ROSEMONT PLACE

PROJECT TITLE: TOWNHOUSE

March 11, 1987

RE: DRAINAGE PLAN FOR ROSEMONT PLACE TOWNHOUSES
(J-13/D29) RECEIVED FEBRUARY 13, 1987

## GRADING AND DRAINAGE PLAN ROSEMONT PLACE TOWNHOUSES

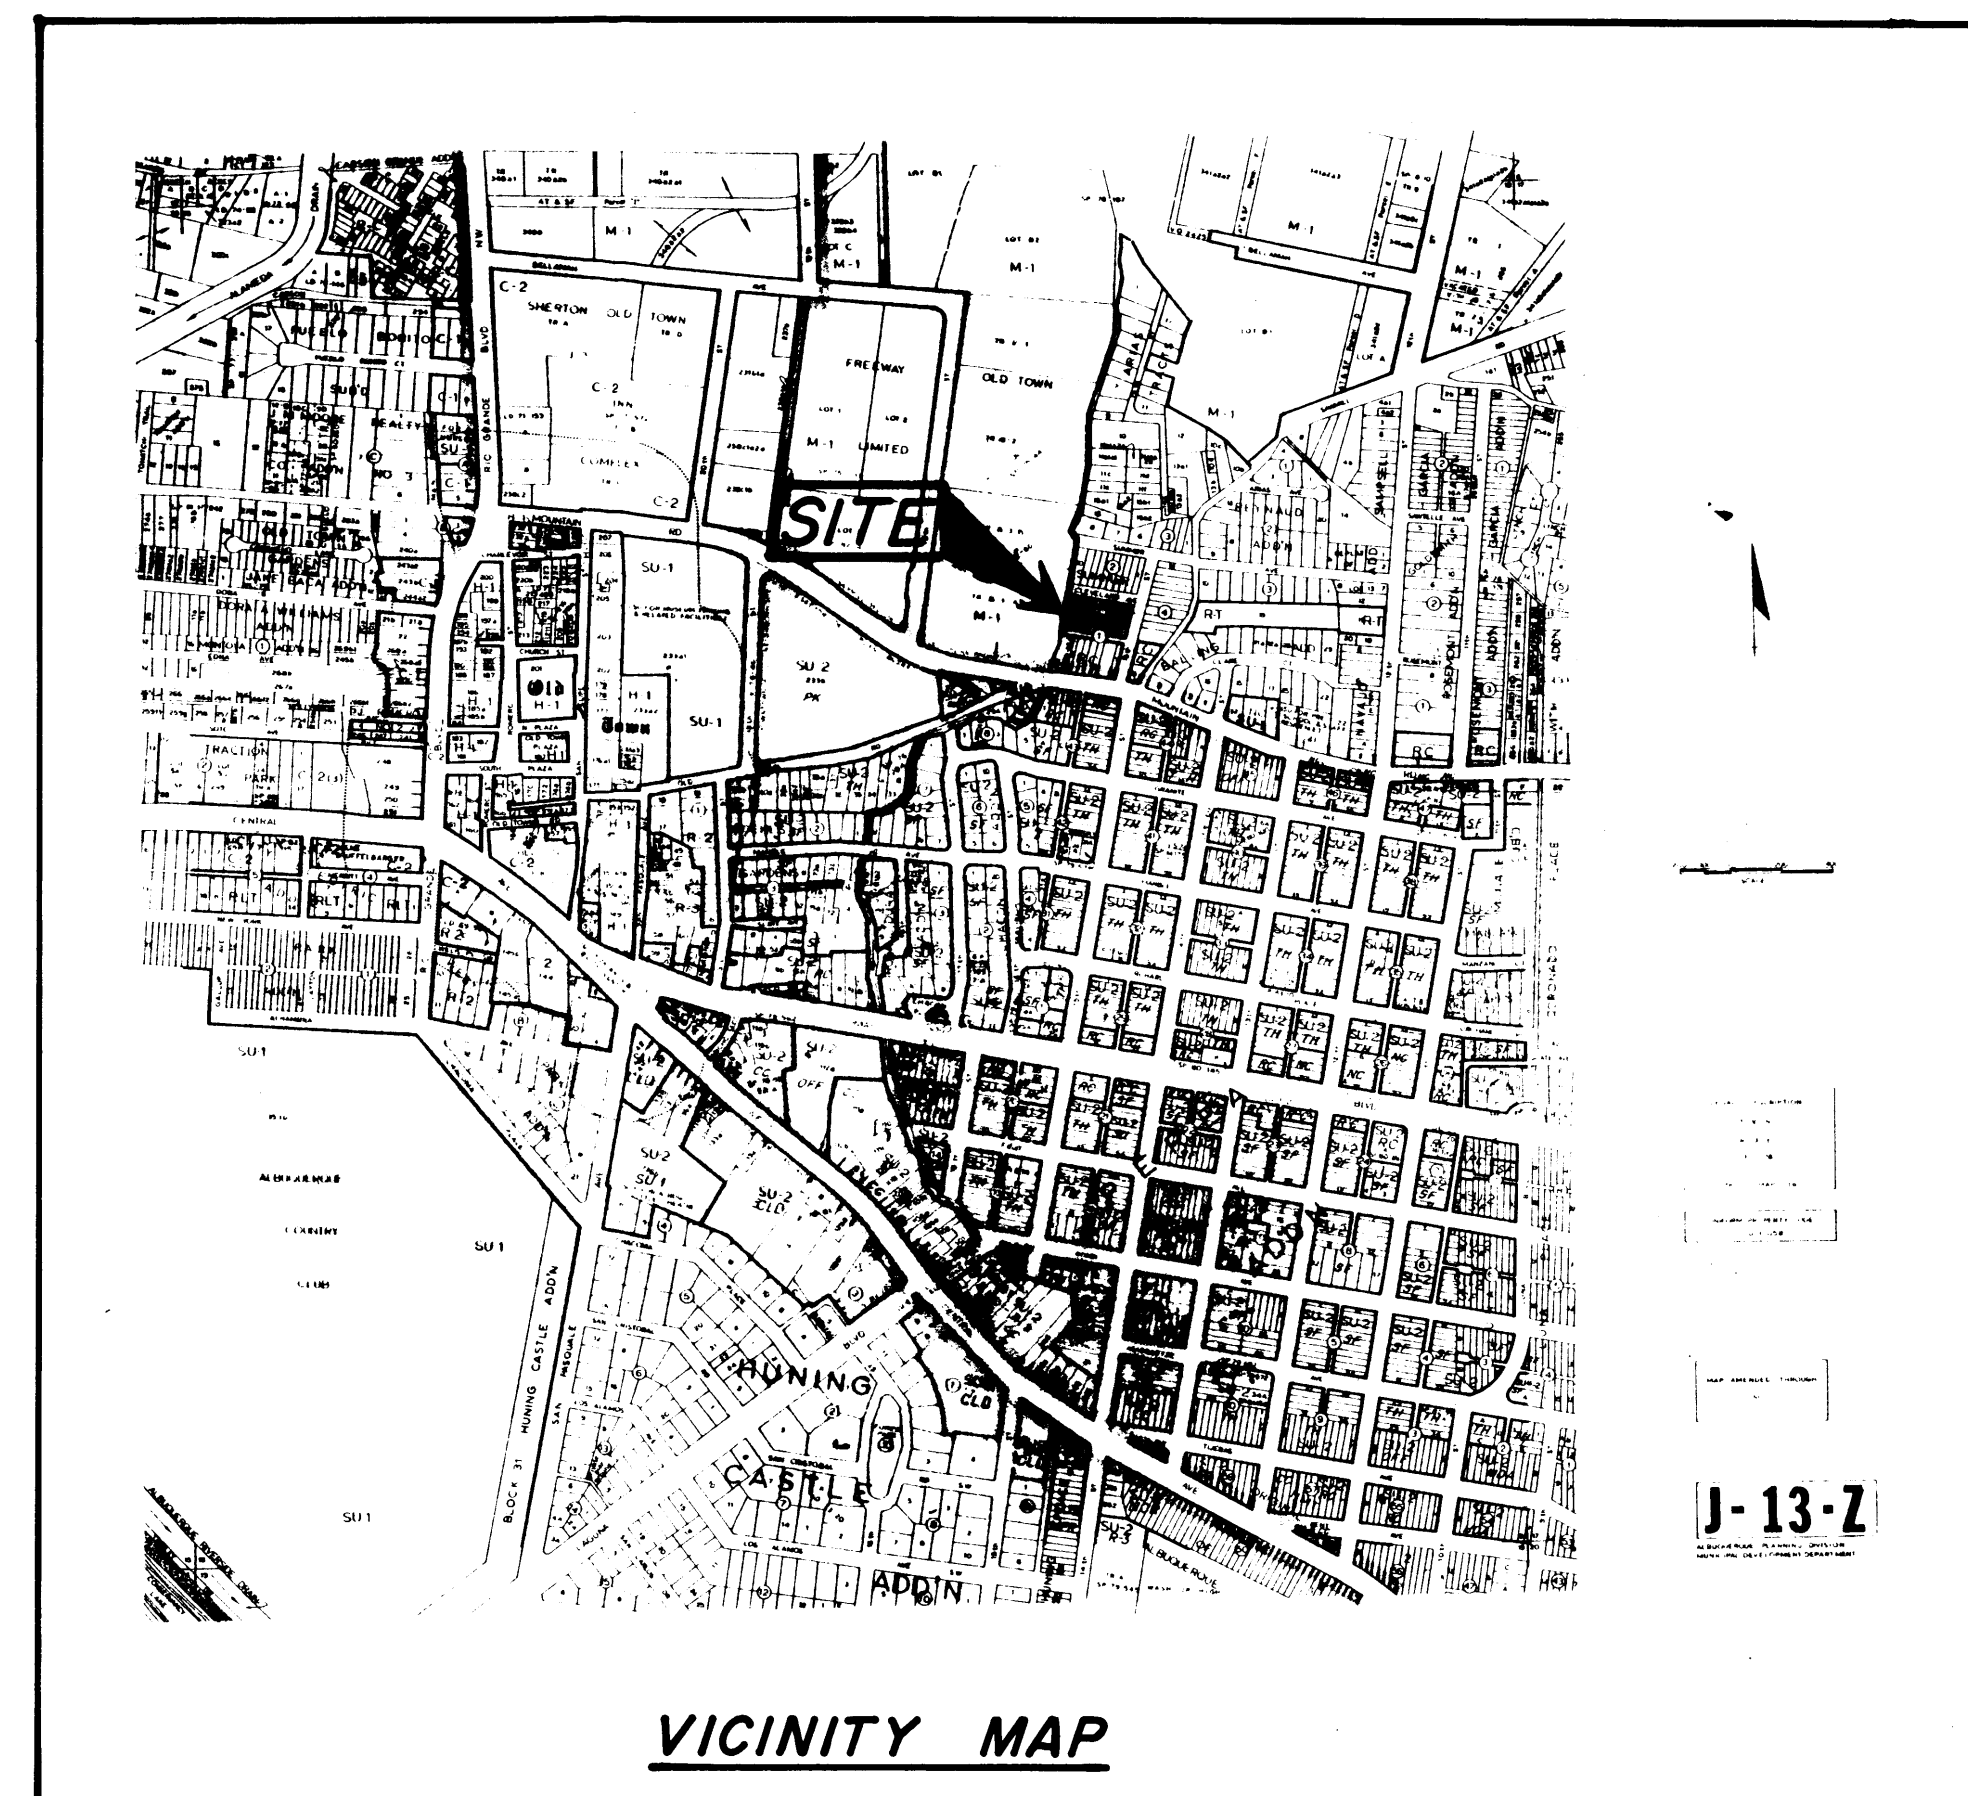
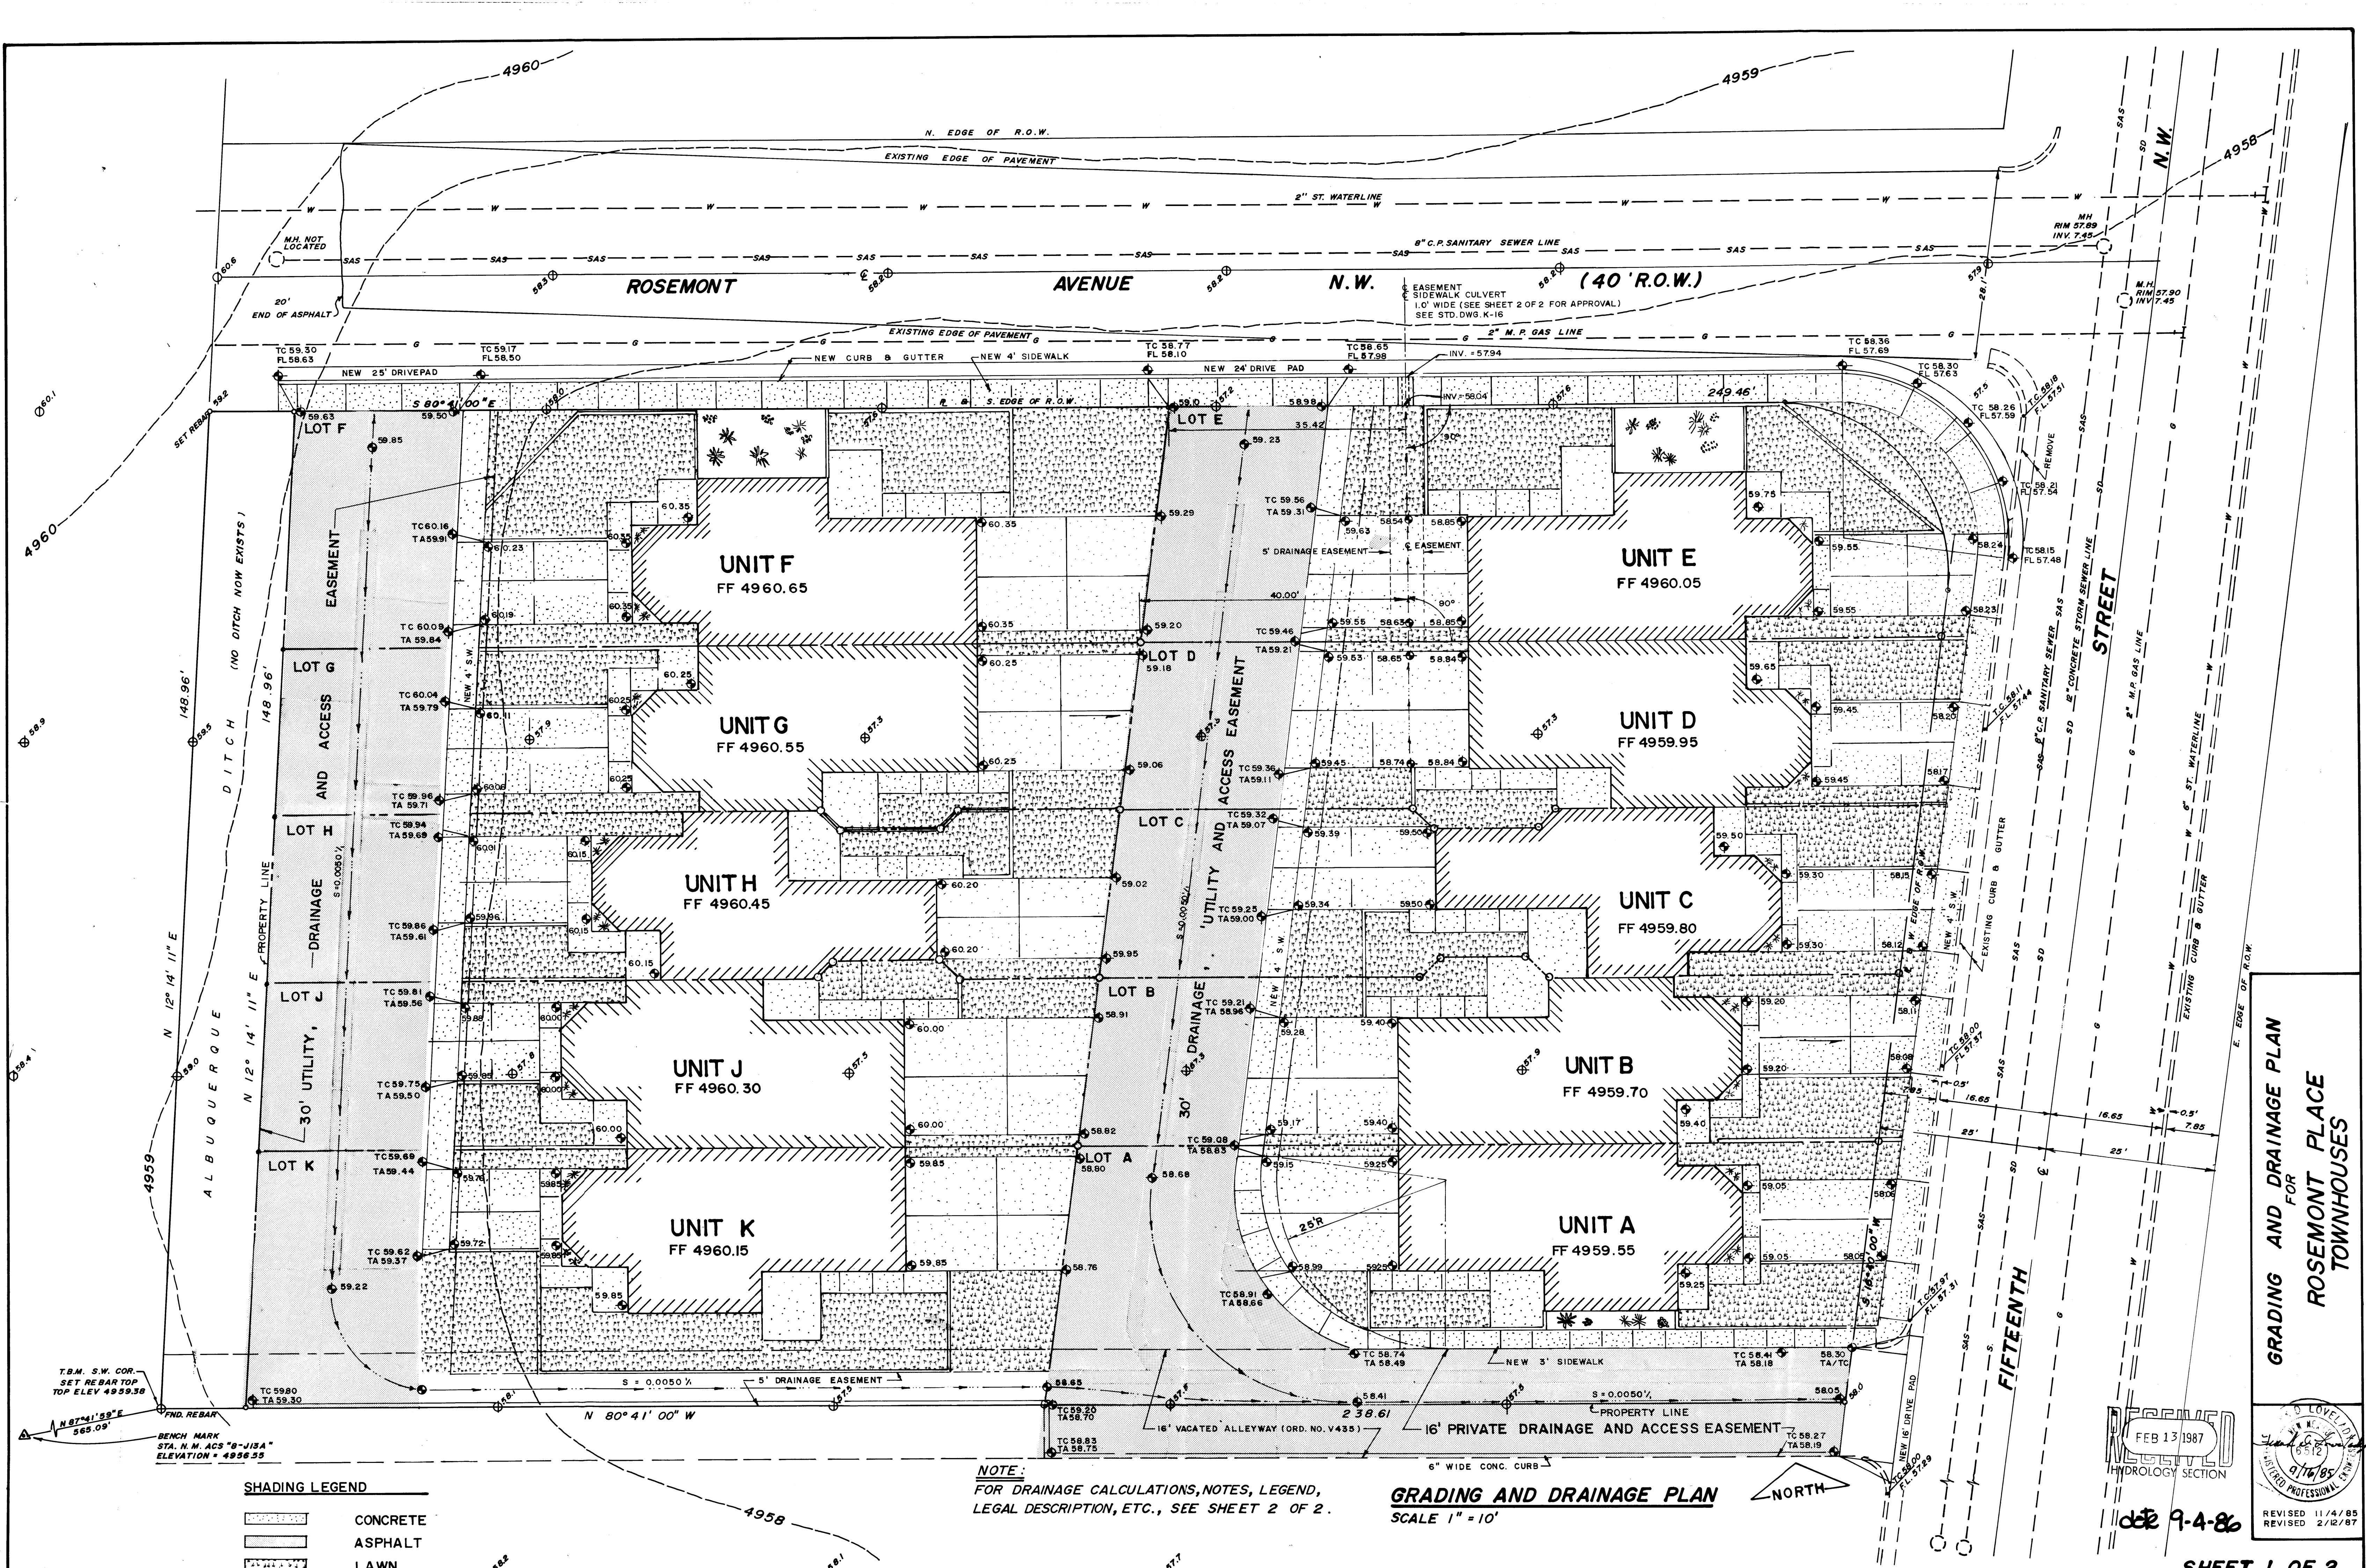
1. Please submit the private drainage easement.
2. How will the flows cross walls at the lot lines?
3. Has Rosemont Avenue been built? Please submit final City approved grades for Rosemont Avenue.
